CITY OF PORTLAND

BUILDING PERMIT

Located At 693 FOREST AVE

Job ID: 2012-02-3298-ALTCOMM

# Typical Wall at elevator Shaft

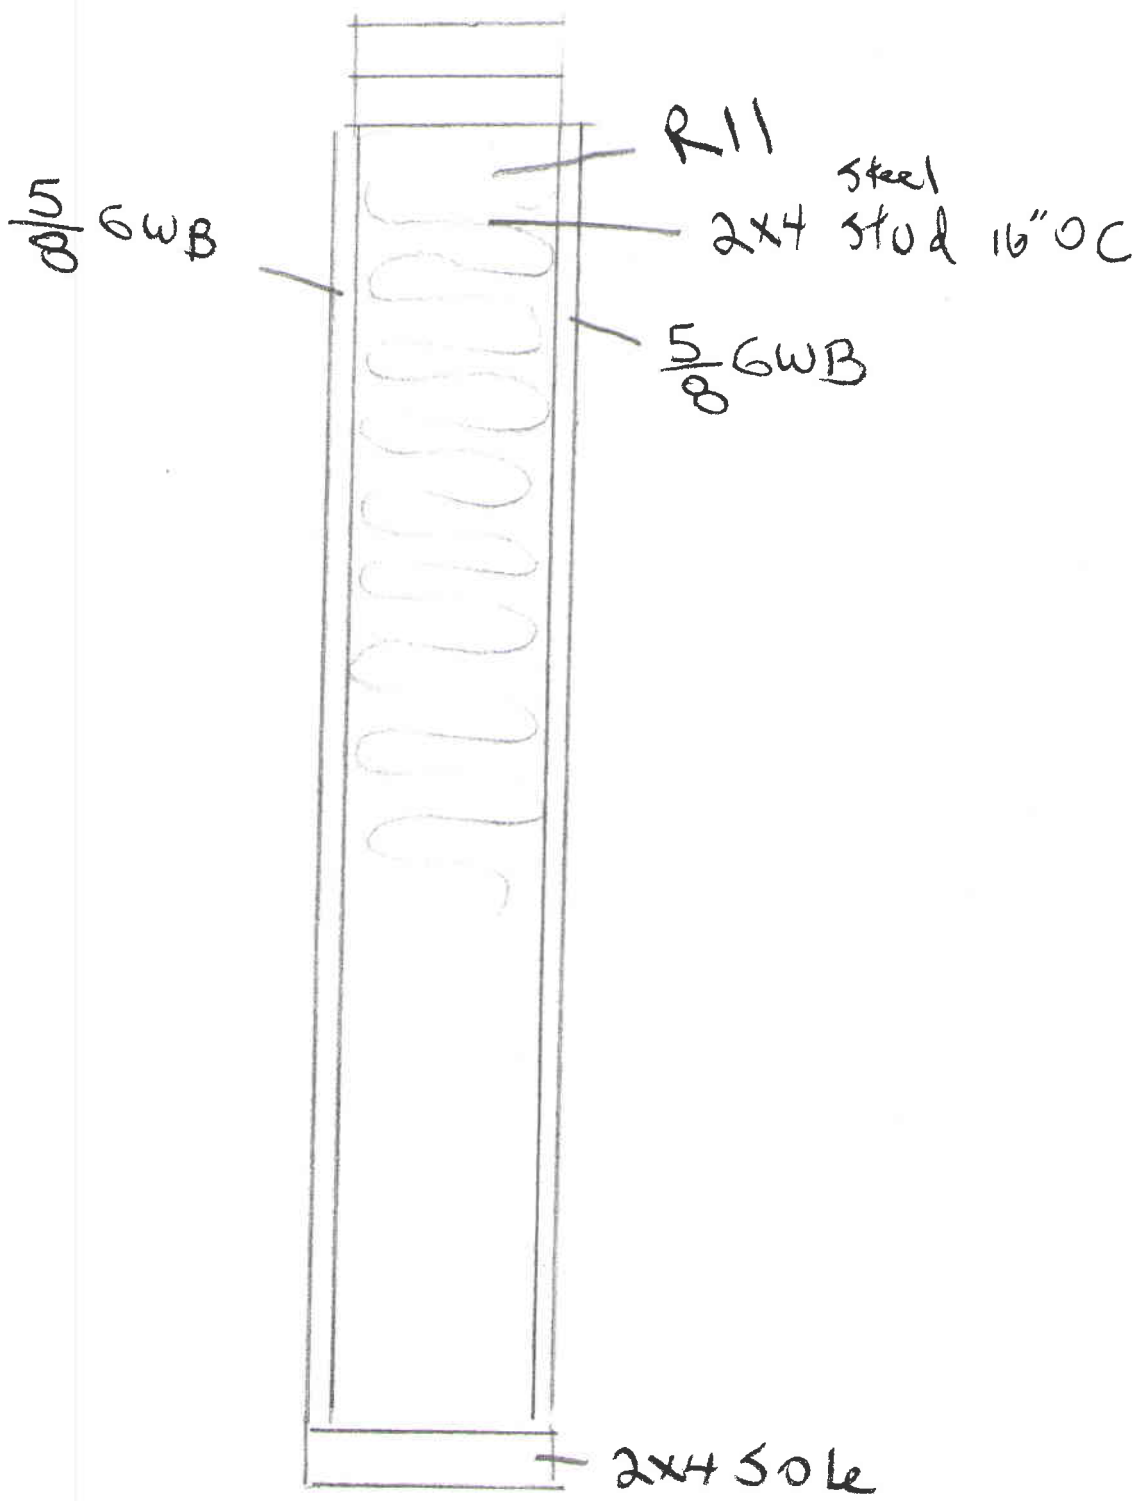
7-20-12 DWM/BKL/Capt Pirone Final Fall
complete shaft, provide 60 min enclosure to basement. Fire egress fail
Basement room enclosed w/o inspection, Bathroom incomplete

4. Vertical openings (Shafts) shall be 60-minute fire rated including fire door assemblies.
5. Any Fire alarm or Sprinkler systems shall be reviewed by a licensed contractor(s) for code compliance. Compliance letters are required.

To reiterate what we discussed on the phone this after noon, this is not a tenant fit up permit but construction only in preparation for a possible future tenant. The scope of work under this permit is to install an ADA bathroom; two exterior window assemblies on the Vannah Street side of the building; build a partition wall for a proposed future kitchen space; and repair a shaft that connects the basement with the top floor level for an existing material lift. A separate fit up permit will be required prior to any certificate of occupancy and will have to provide a life safety plan for the entire space as well as kitchen equipment and use plan(s). The conditions on this permit will reflect this and that the shaft must be 60-minute fire rated including fire doors.
